PLANNING AMENDMENT

APPLICANT NAME AND ADDRESS Mr B Johnson 32 Broad Lane Moulton Lincs PE12 6PN Telephone: [REDACTED]		AGENT NAME AND ADDRESS Cooper Architectural Design 90 Winsover Road Spalding Lincs PE11 1HA Telephone: 07808125778	
SITE ADDRESS DETAILS R/O 32 Broad Lane Moulton Lincs PE12 6PN			
CURRENT APPLICATION NO: This amendment cannot be considered unless the relevant reference is stated.		H13-0869-22	
Building Regulation reference relating to same development (if applicable)			
I attach four copies of this form and necessary plans and request that the changes described below can be accepted as an amendment. As the amendment relates to a current application, I agree to an extension of the terminal date (if applicable). Signed : John Cooper Date: 21-10-2022			
FULL DESCRIPTION OF DEVELOPMENT OF CURRENT APPLICATION THAT THIS AMENDMENT RELATES TO		Details of landscaping and tree planting, proposed boundary treatments/screening and foul and surface water disposal. (Conditions 3, 4 and 6 of H13-0909-19)

BLOCK & LOCATION PLANS

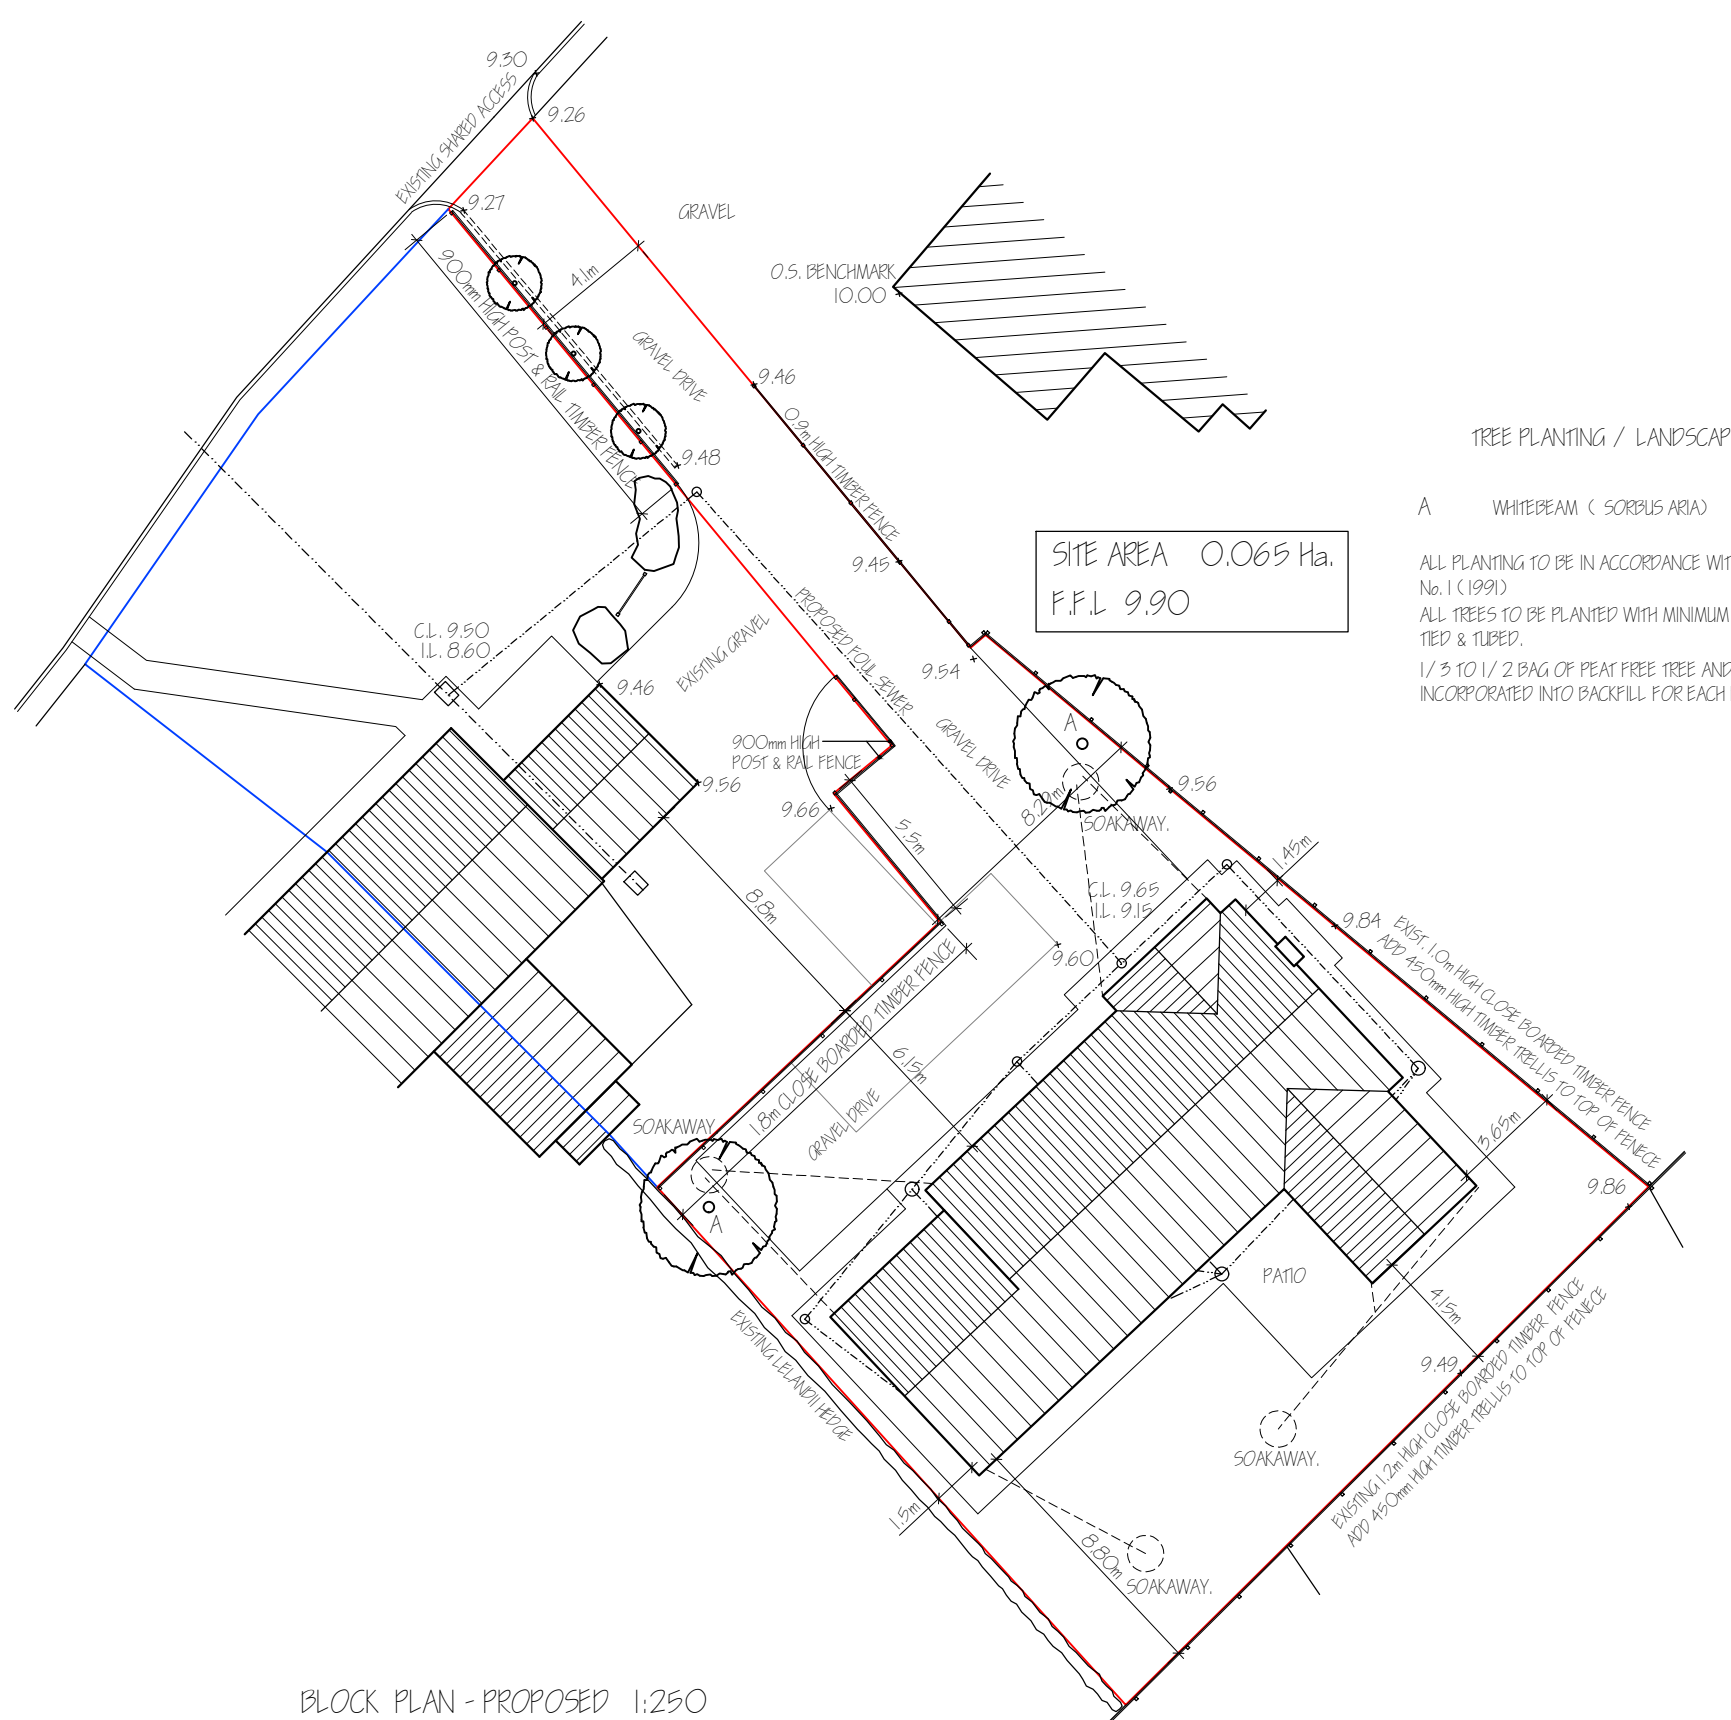
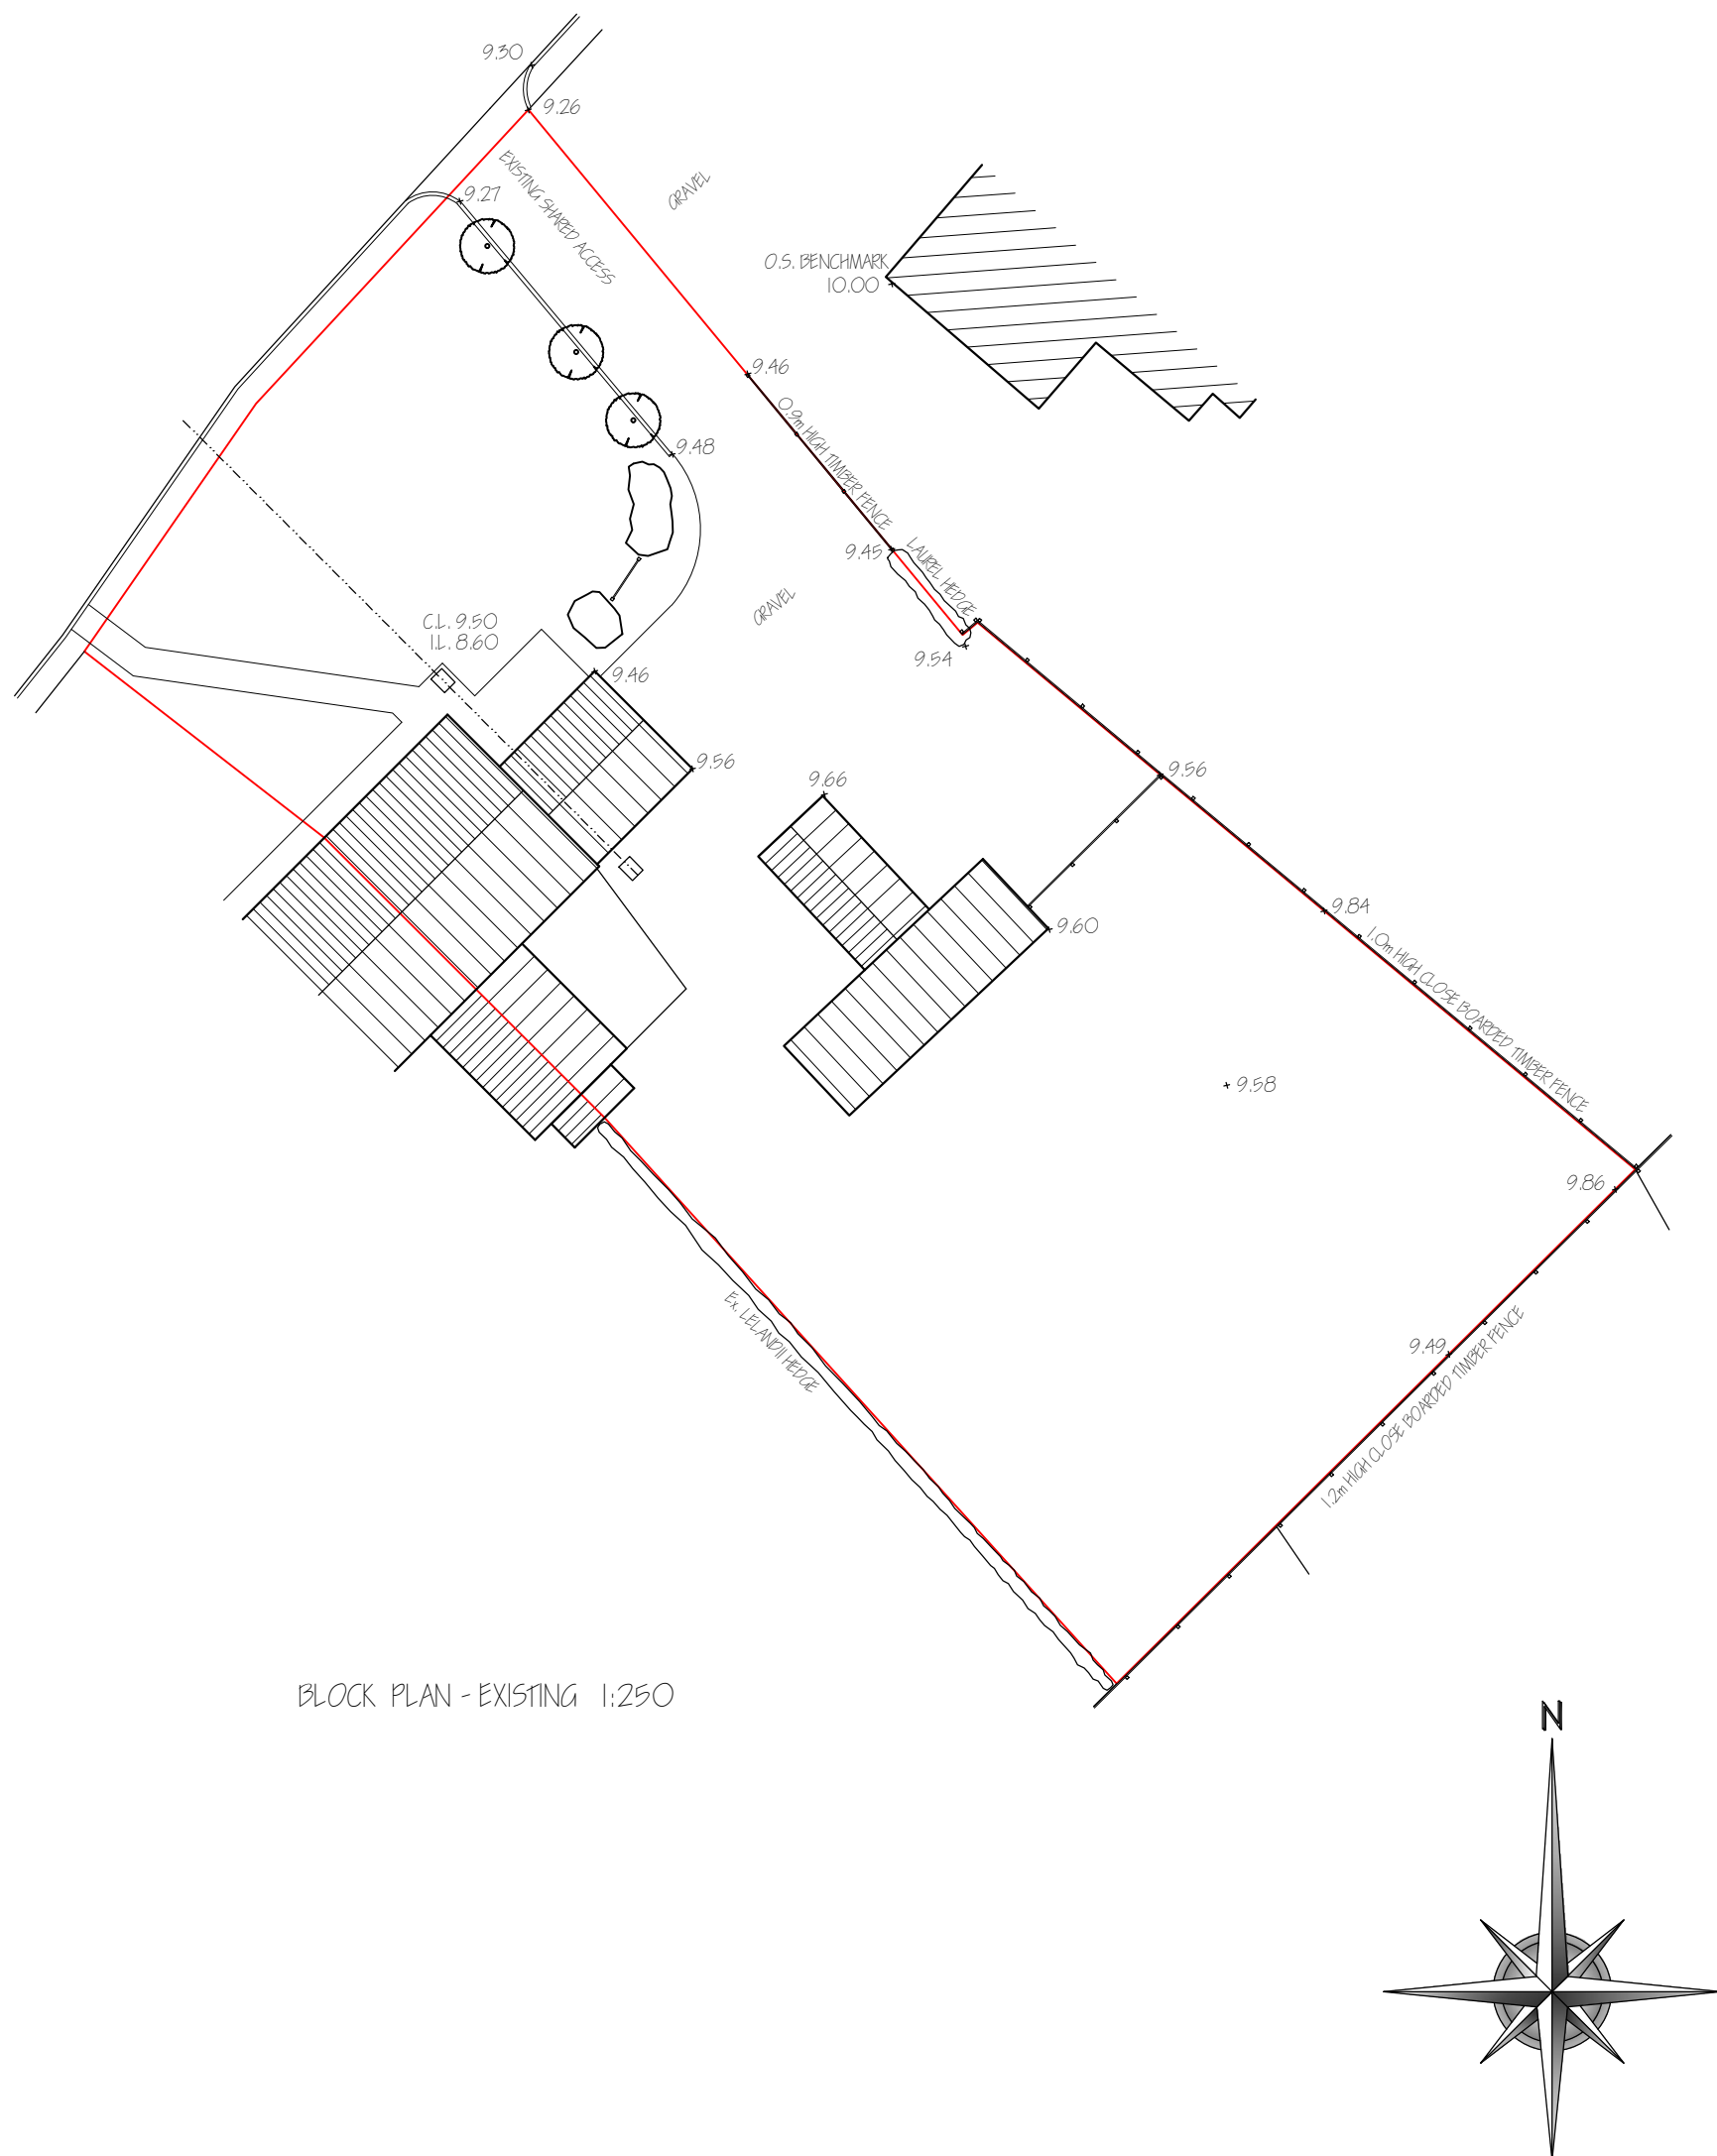
State details of amendments proposed. (Give a full detailed list of the changes, and also mark these clearly on the accompanying plans. Only the changes listed here will be considered)		North-East & South-East boundaries to have 1.8m high close boarded fencing in place of existing fencing with trellis.	
State drawing numbers of the current submission		1904-01-B	
Has this amendment been requested by the Council? (If so, state Officer dealing with the application)		YES	David Gedney
Describe any part of the original development which is excluded by virtue of the amendment, and state any alteration to plot numbers			
Has a similar amendment been submitted under Building Regulations? (If so, state Building Control Surveyor dealing with application)		NO
